## **Leachate Treatment Plant Response to Submissions Report**

**October 2017**

**Table 3-1 Responses to comments made in submissions received**

Figure 3: Bioreactor layout and existing leachate management system

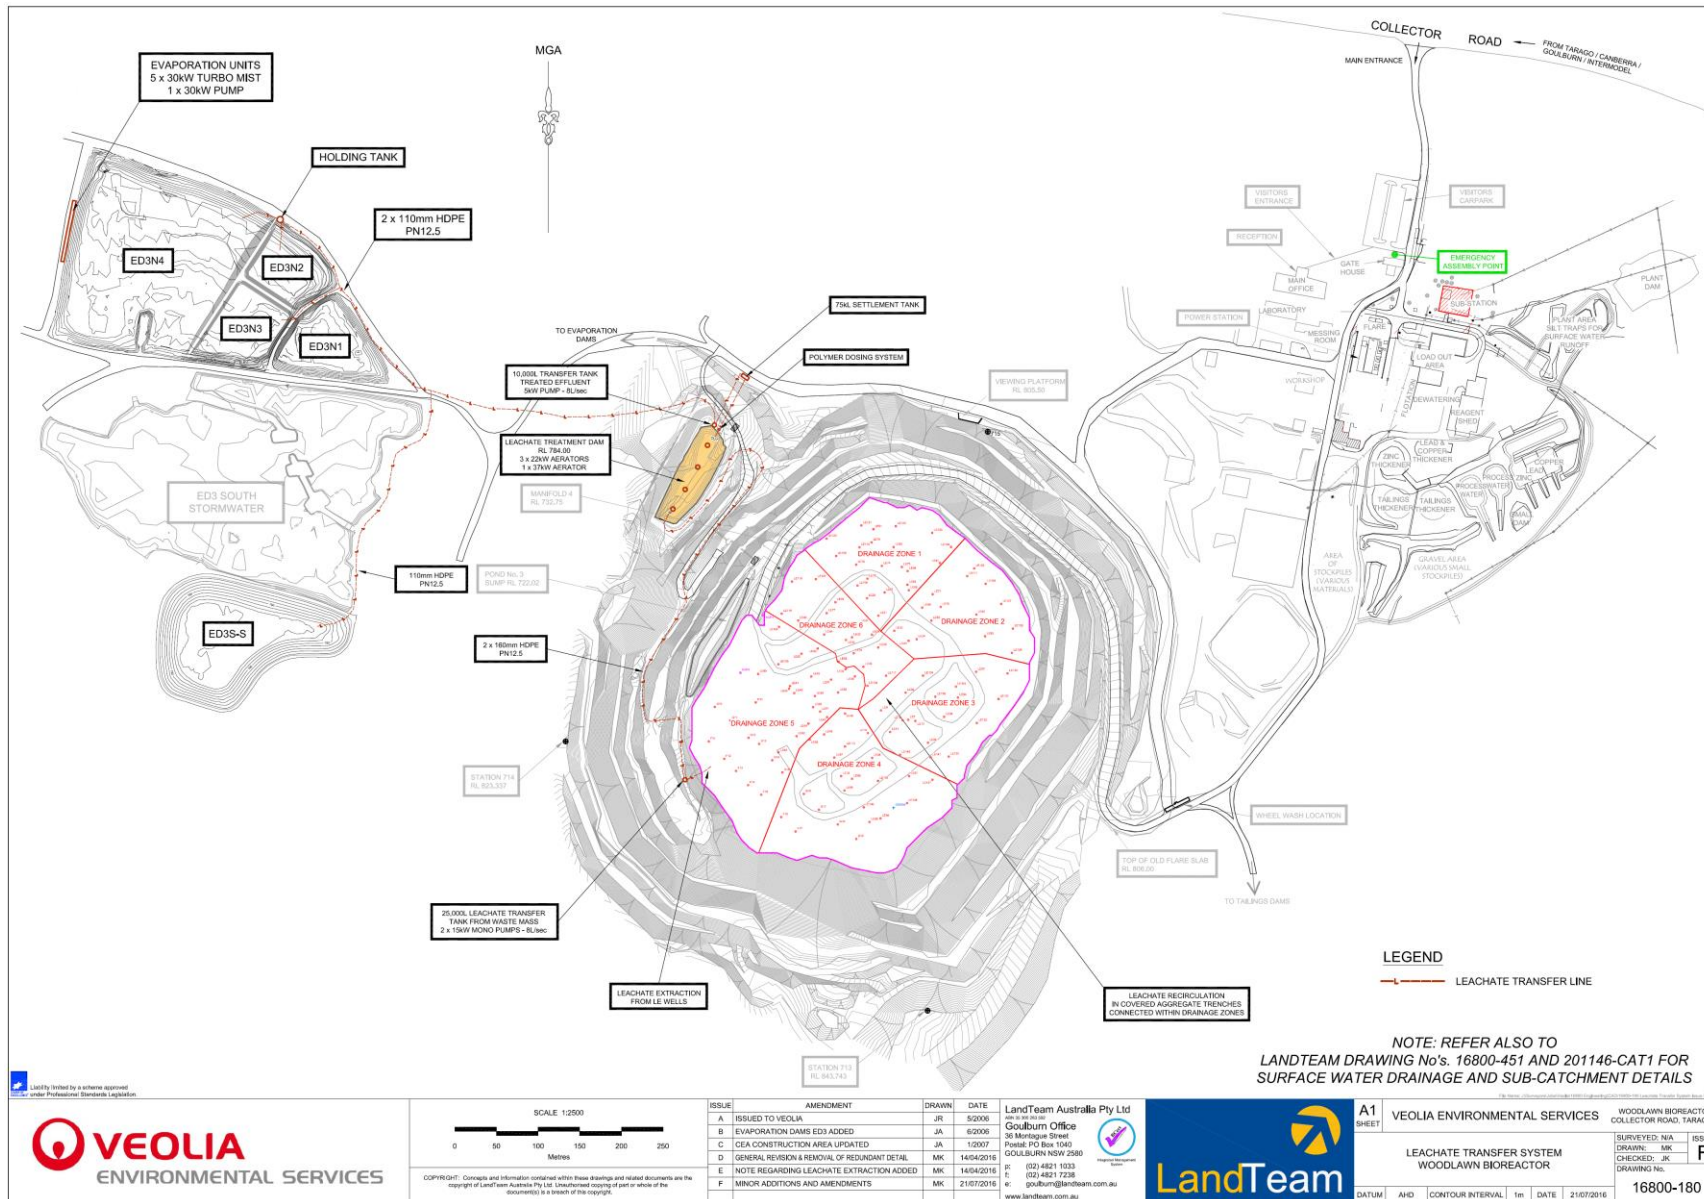
2. Please ensure all references to evaporation dams are correct.	Noted	
3. Please provide a plan which illustrates the existing and proposed leachate storage dams and stormwater storage dams.	Figure 3 on page 12 of the Environmental Assessment report for the proposed modification provides details of the existing leachate storage systems and figure 1.2 on page 3 of revised water balance – September 2017 provides details for the proposed leachate storage	Figure 3 in section 1.2 of the Environment
